The Member-Secretary,
Madras Metropolitan
Development Authority,
No.8, Gandhi-Irwin Road,
Egmore, Madras-600 008.

Lr.No. D.Dis. A2/16967/90

Sub: MMDA - Planning Permission - Additional
construction of Residential building in
First Floor at Plot No.163 at S.No.67part
of Thiruvannmiyur village - Approval - Reg.

SITE PLAN CUM GROUND FLOOR PLAN

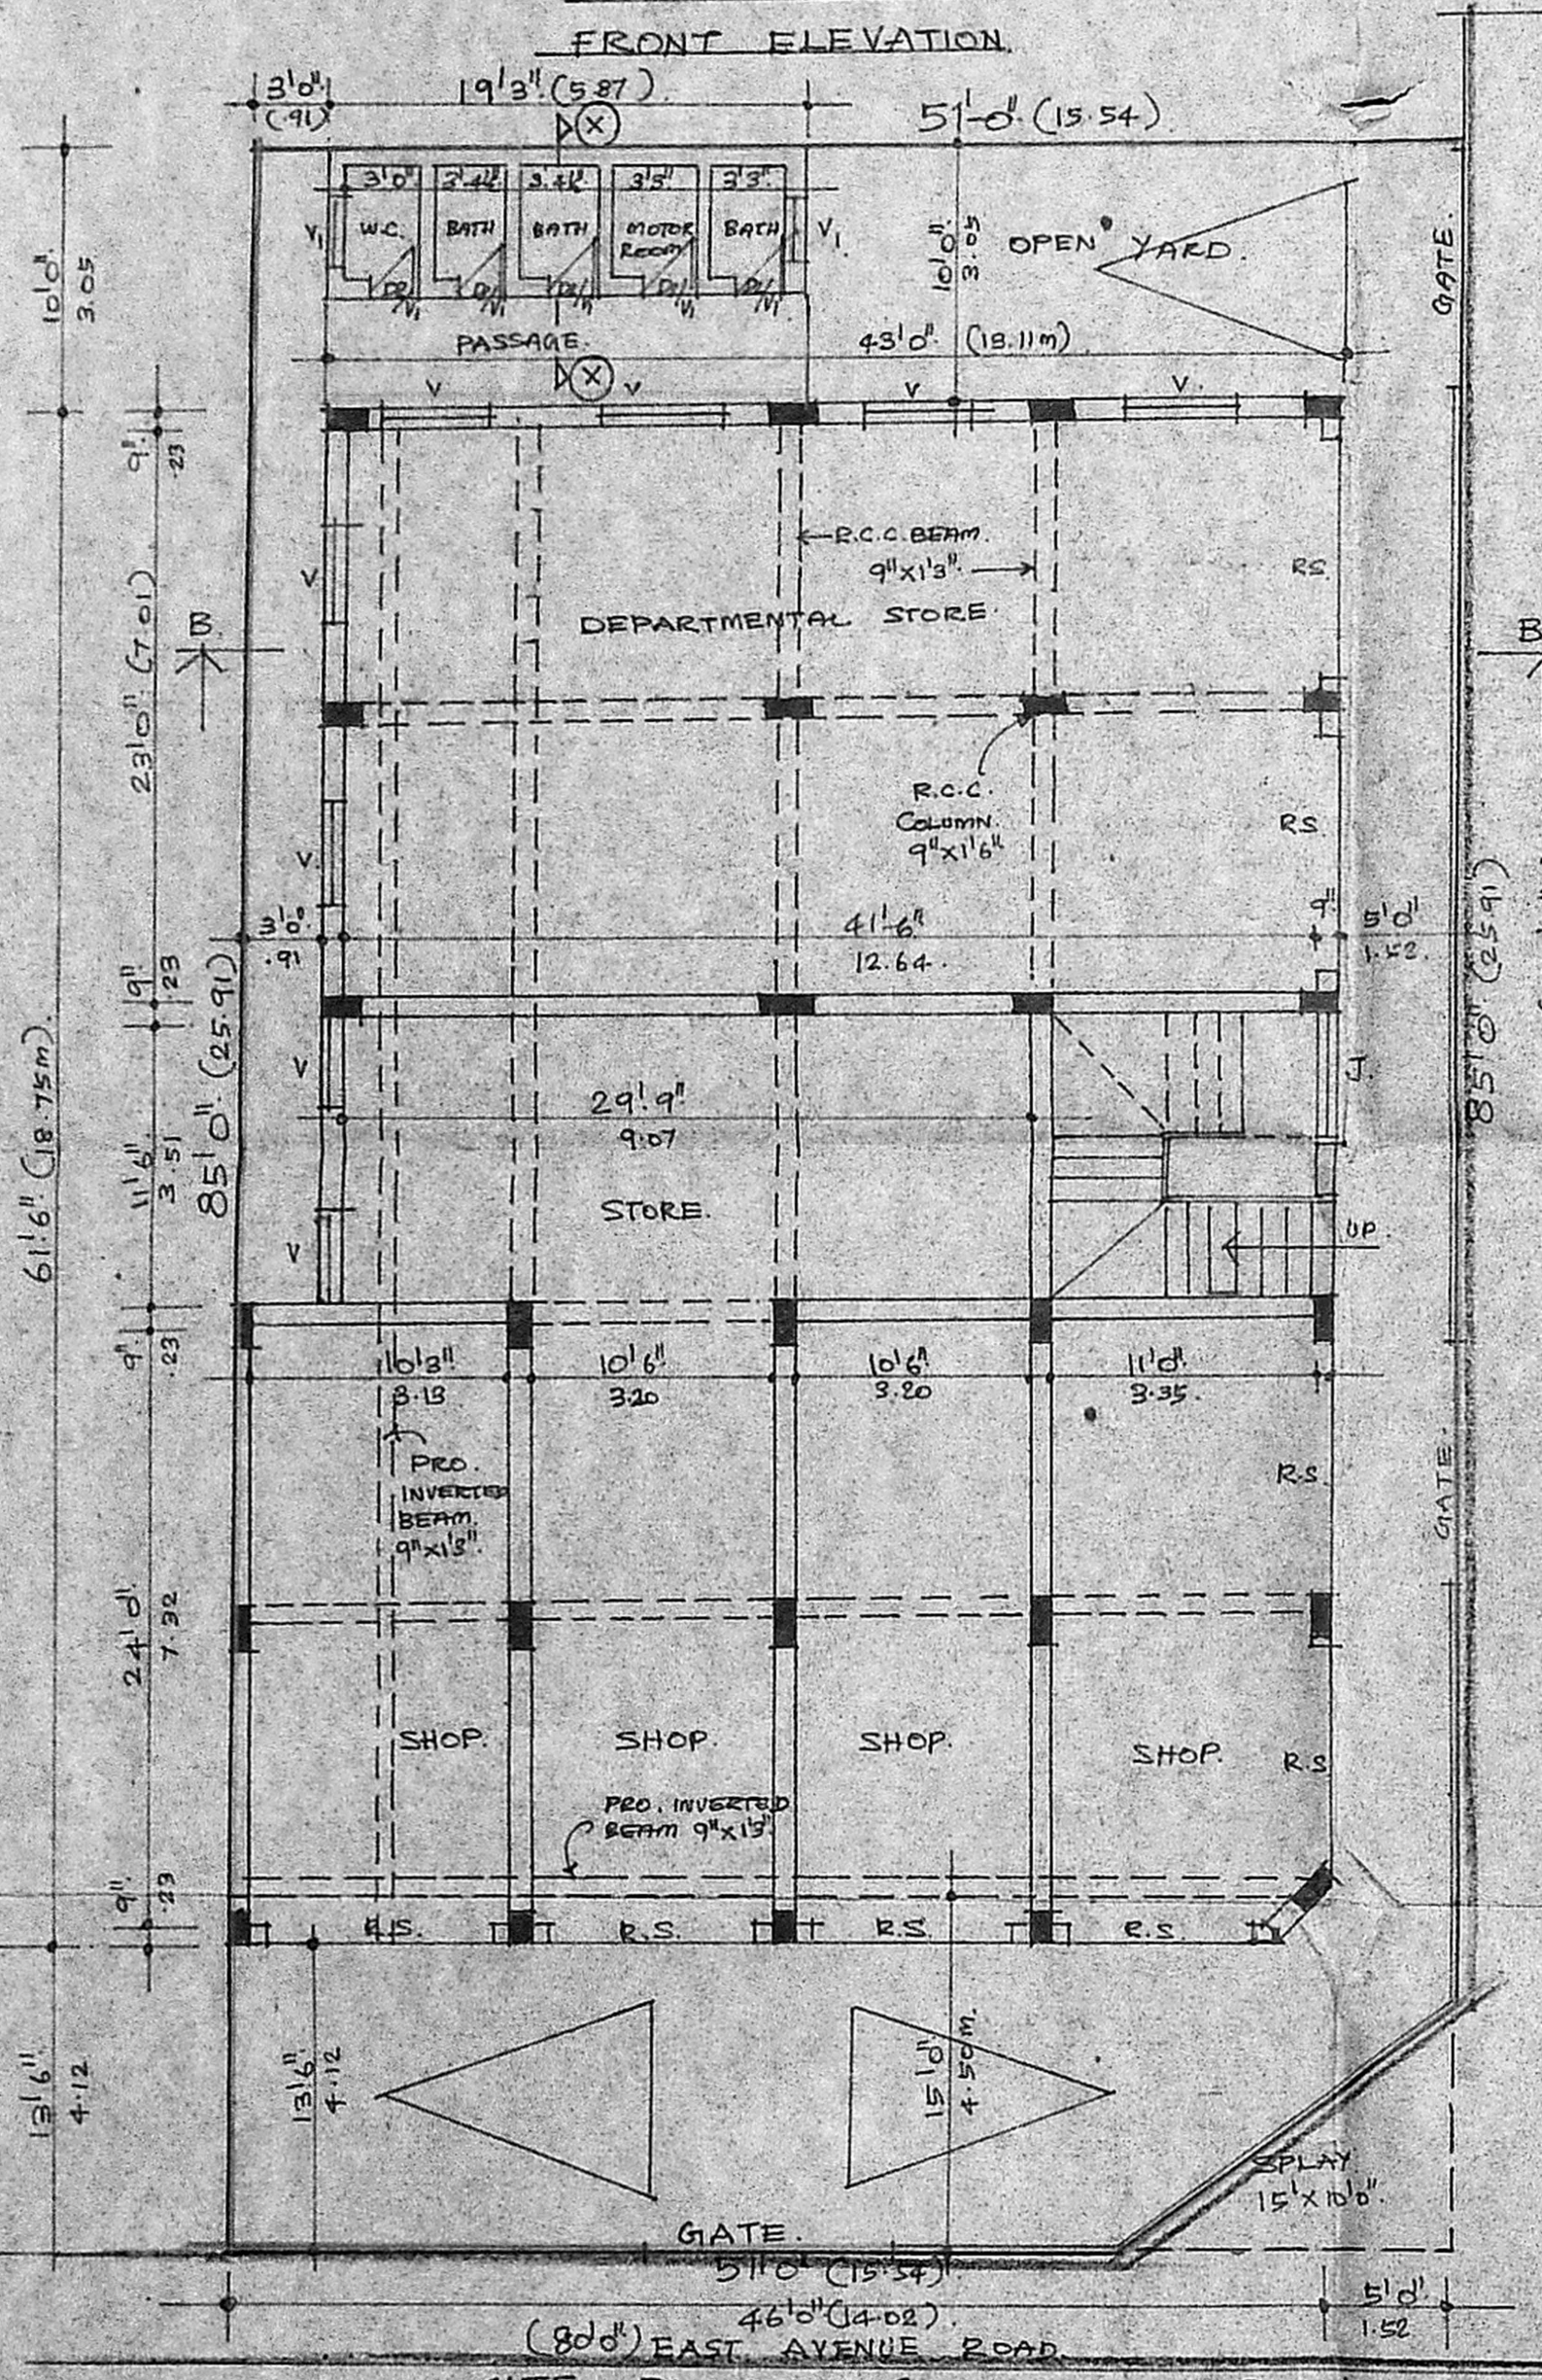
The reconsideration petition received in the reference
cited for the additional construction of building for residential
purpose in Plot No.163, East Avenue Road at S.No. 67part of Thiruvannmiyur
village was examined and found that the planning permission for the same
is issuable by relaxing Front, Side Set Backs and Corparking require-
ments subject to condition that --

- i) The rear structure used for Bath & Water Clesset should be demolished
i) 'in the Open space within the site to the extent feasible trees be planted and the existing trees preserved' after completion of the first floor.
- ii) 'it was requested to ensure that the plans for the new buildings will incorporate the approved designs for mosquito-proof overhead tanks and wells'
- iii) 'improvement charge, Open space reservation charge and other charges as applicable'.
